re: **Grading Plan Review**
 Proposed Residential Development - Morgan's Creek Stage 1
 762 March Road - Ottawa

file: PG2234-MEMO.07 Revision 1

- Grading Plan - Project 24566-001, Drawing G1, Revision 5 dated June 28, 2019.

DRAWING:  
**GRADING PLAN**

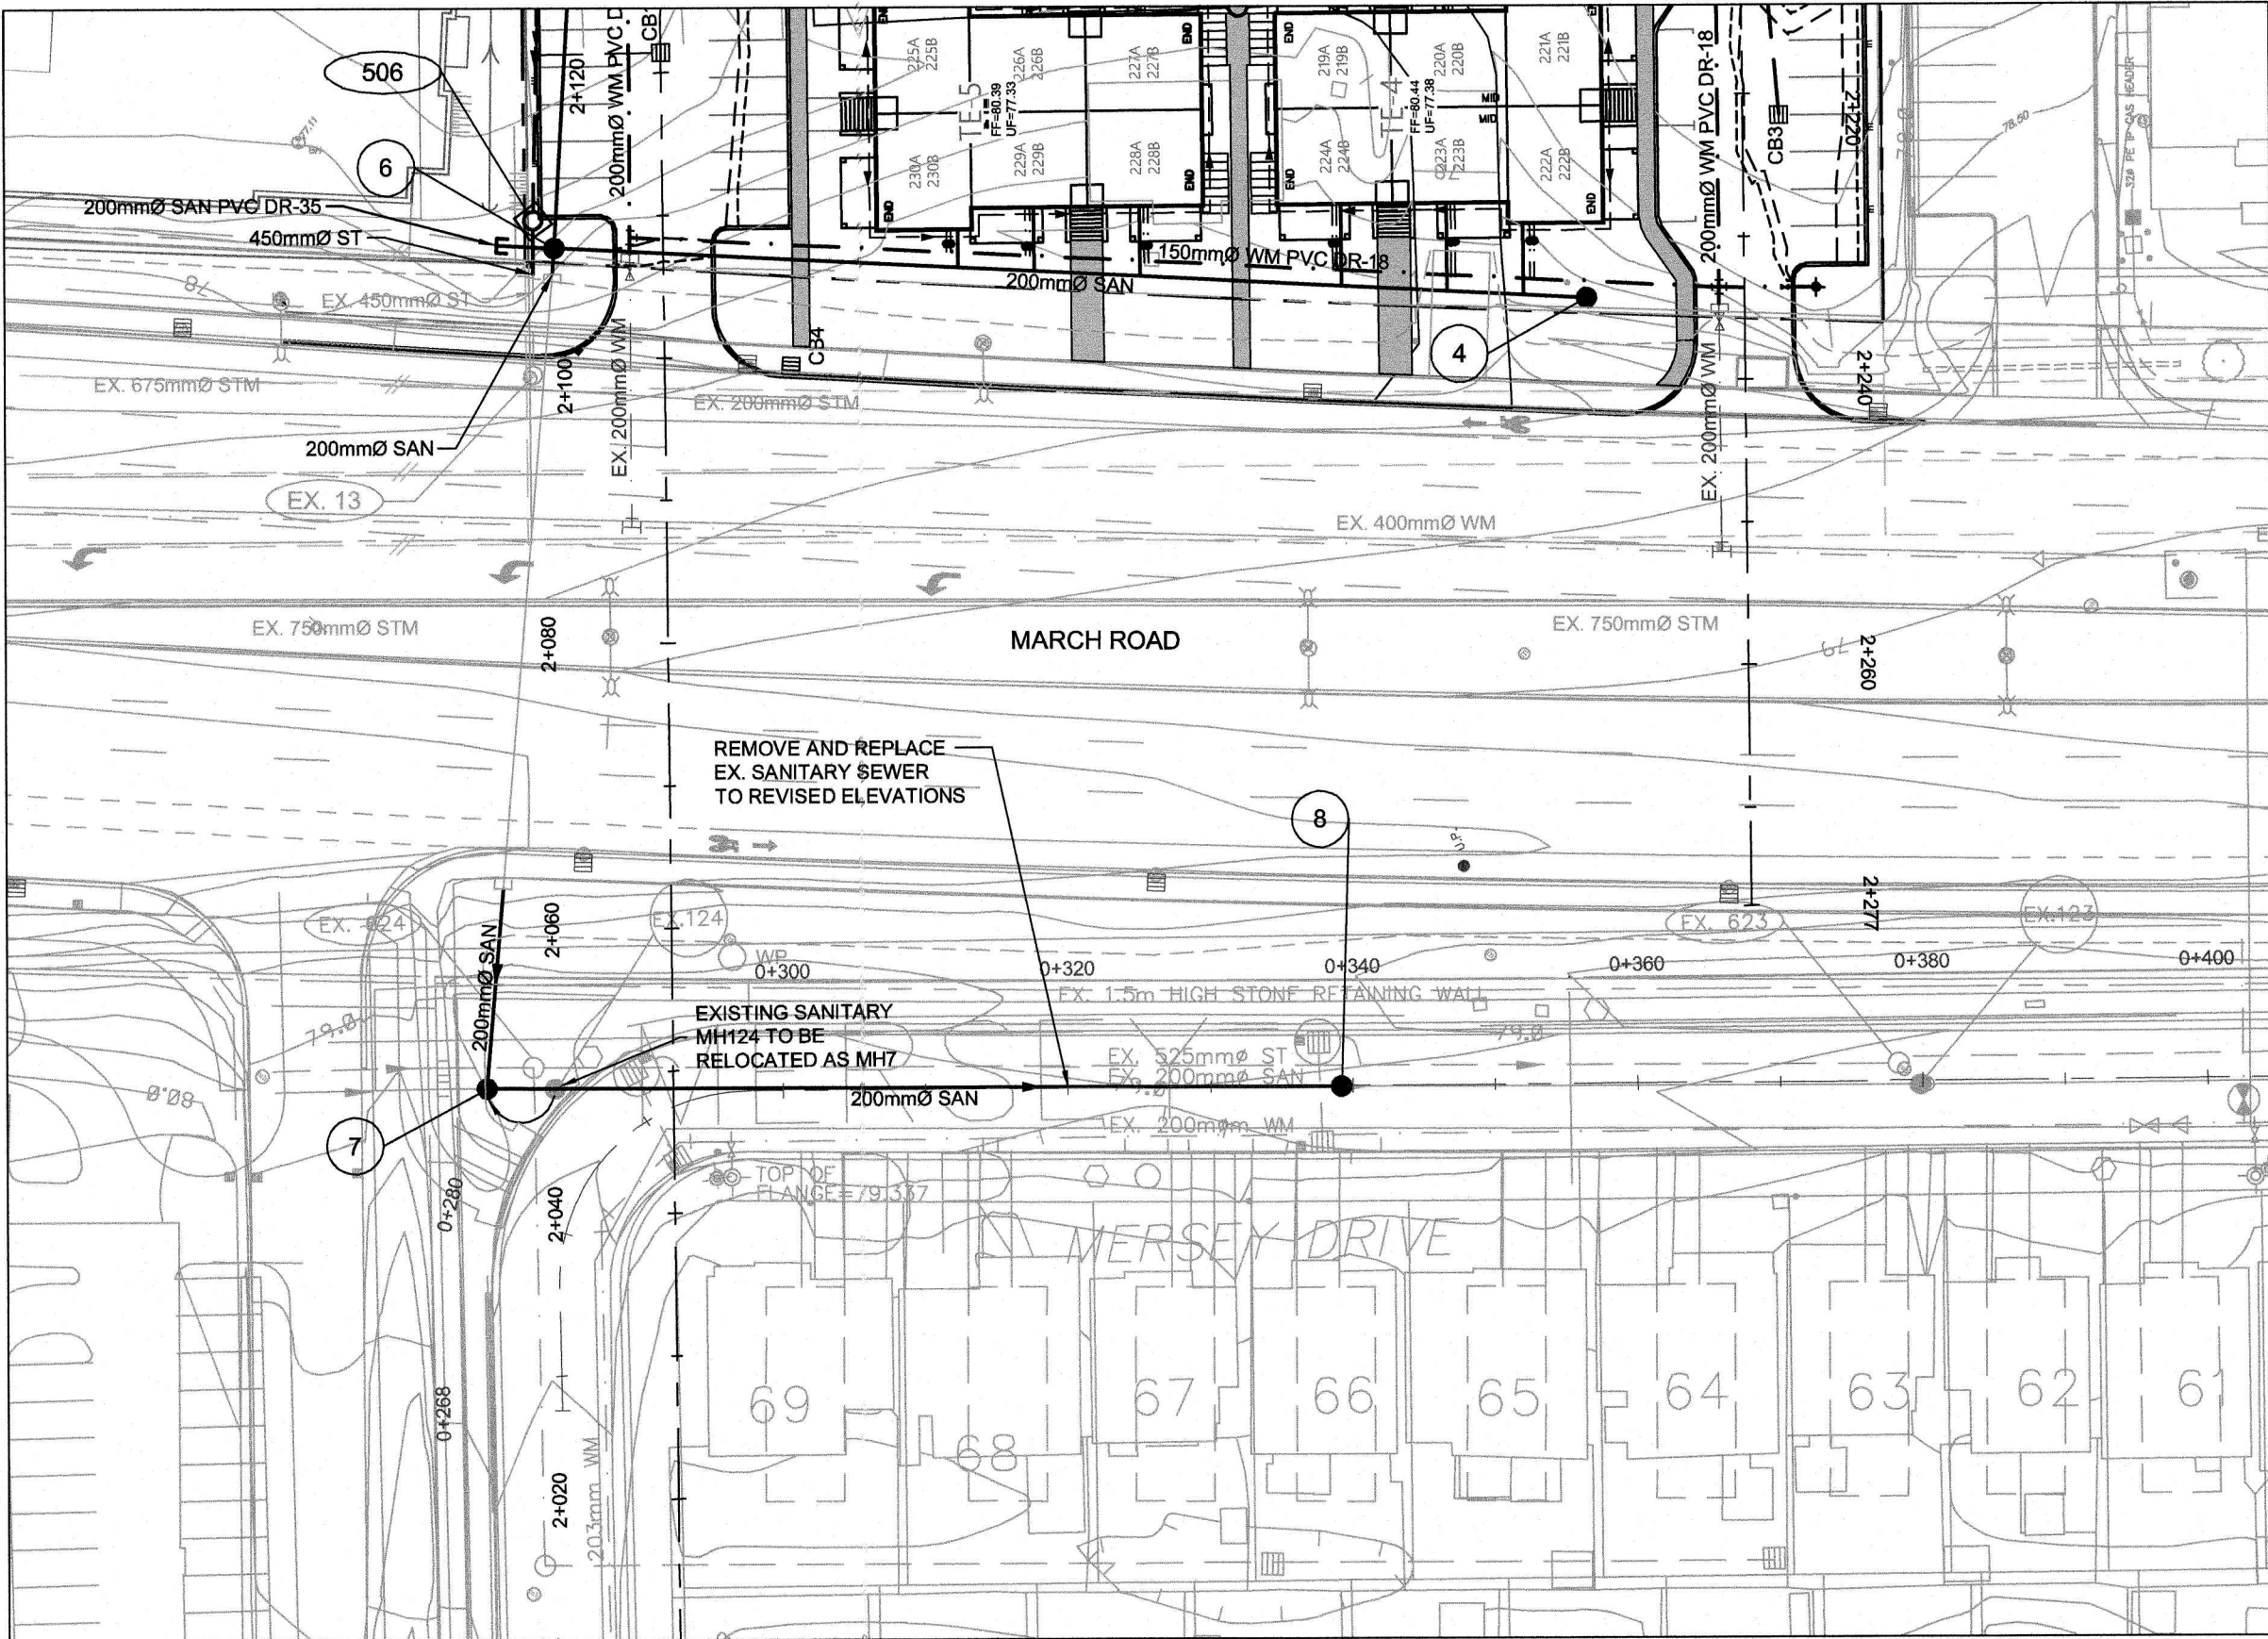
In summary, finished grades at the site are generally within the 3 m permissible grade raise, with the exception of the following areas:

- Block TE-1, Unit 201 extending 2.4 m east and north to the proposed walkway.
- Block TE-1, Unit 202 extending 2.4 m east to the proposed walkway.
- Block TE-1, Unit 203 extending 2.4 m east to the proposed walkway.
- Block TE-2, Unit 207 extending 2.4 m east and north to the proposed walkway.

The proposed townhouse blocks will incorporate basements, therefore, in order to mitigate long-term differential settlement, it is recommended that lightweight fill be placed in the above-noted areas.

Complete grading details for each Block and Unit as per our review are provided in Table 1, attached to the current memo. Details regarding installation of expanded polystyrene (EPS) blocks are provided in Figure 1, also attached.
